Your Ref: OWPC25432
Our Ref: EP/157/19/HH 29-11-2019
Please ask for:
Zac Denton

First floor extension and changes to cladding and finishes.
St Briac South Strand East Preston

Project: Proposed extension; St. Briac, South Strand, East Preston BN16 1NY	
Drawing: Elevations as proposed	
For: Mr. J. Trusson & Ms. L. Byrne	
Drawn: PKS	Date: November 2019
Scales: 1:100	No: 2510/01/03
To scale when printed on A3

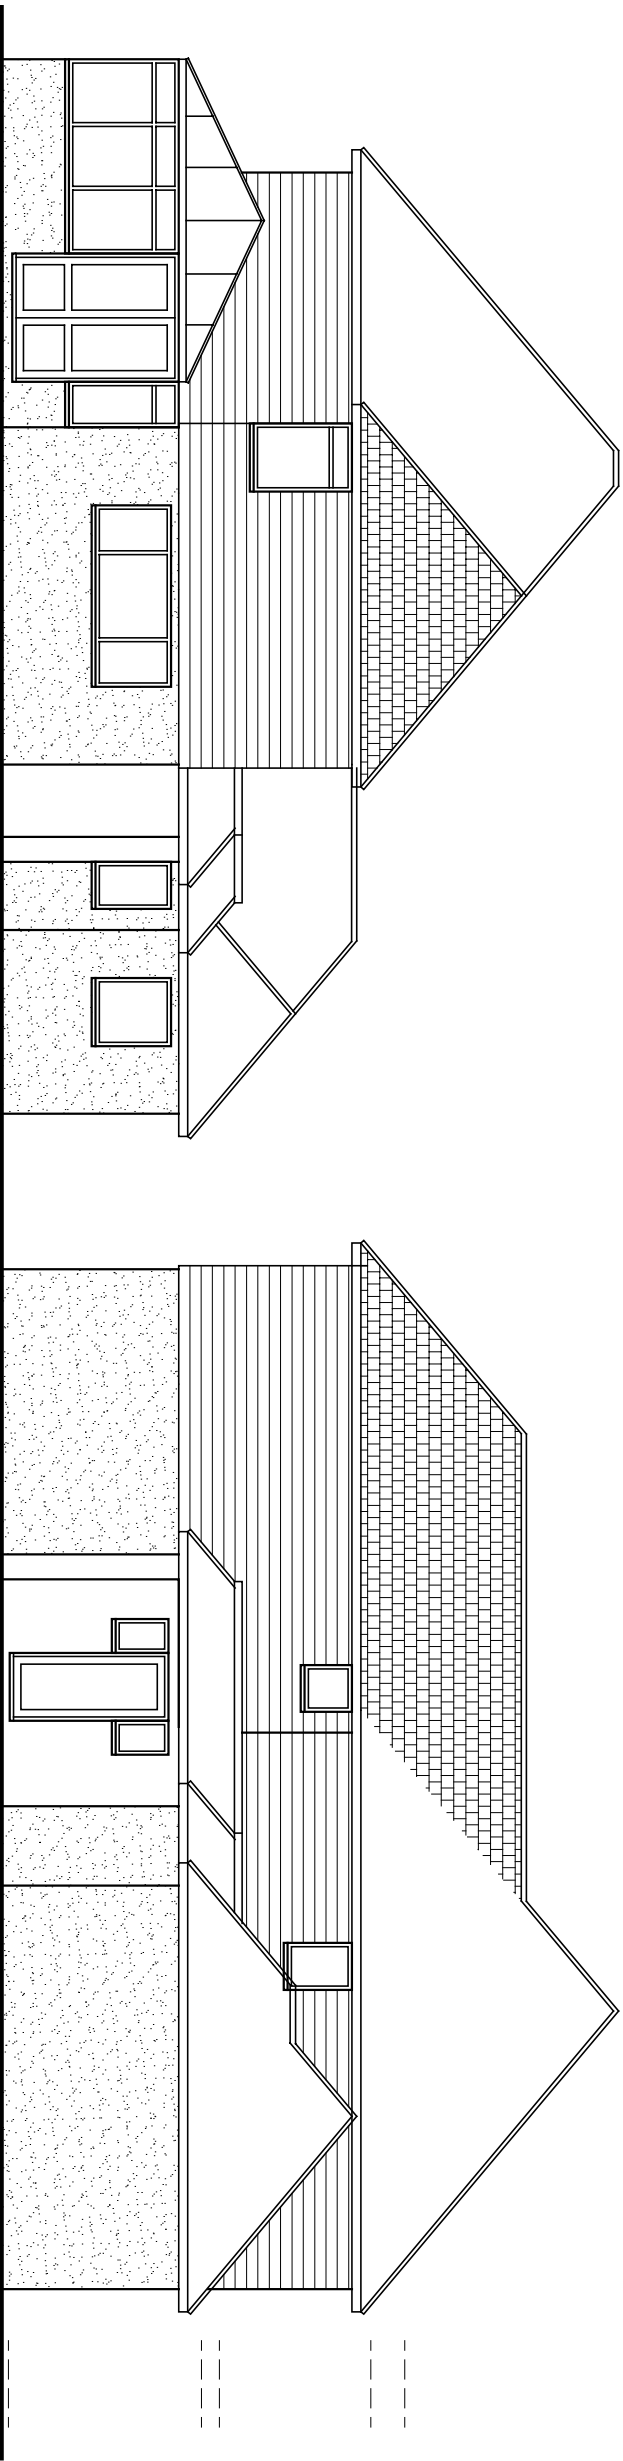
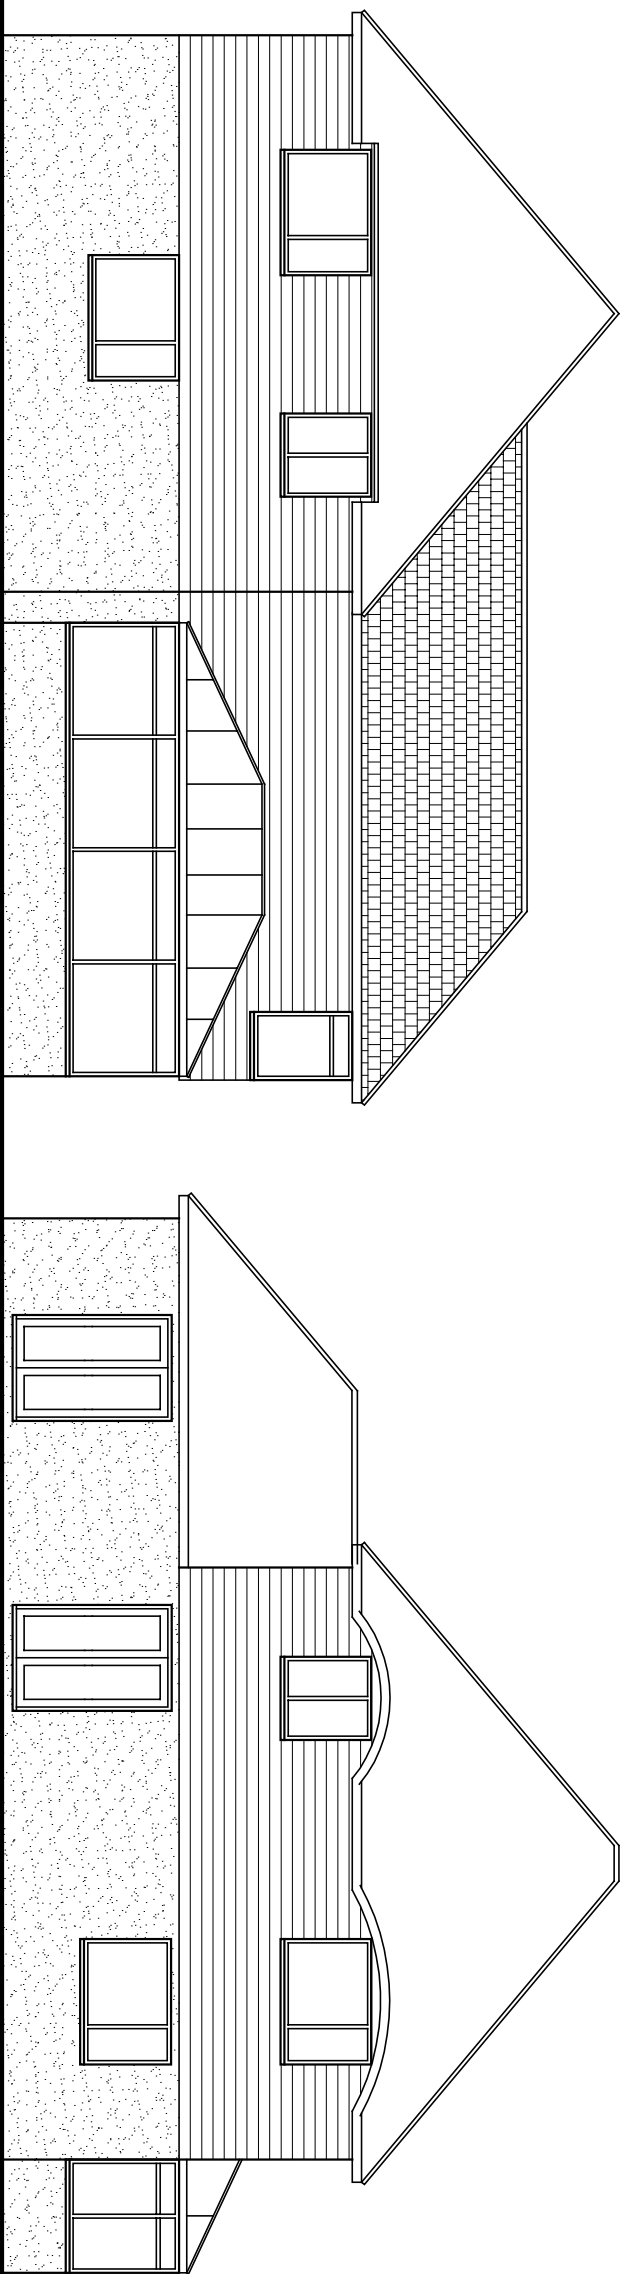
The Society does not object to the proposed rear extension. It does, however, object to the proposed materials. The use of grey Cedral cladding to replace the existing wooden cladding would introduce a material that is alien to its surroundings. Combined with the new windows, it would create grey walls, which would not harmonise with the clay tiles of the roof.

These materials would not harmonise in colour and texture with the materials used in the surrounding area. Their use would therefore be incompatible with policy D DM1 of the Local Plan.

This application should therefore be refused. It could be approved if materials which harmonised with the surroundings were adopted.
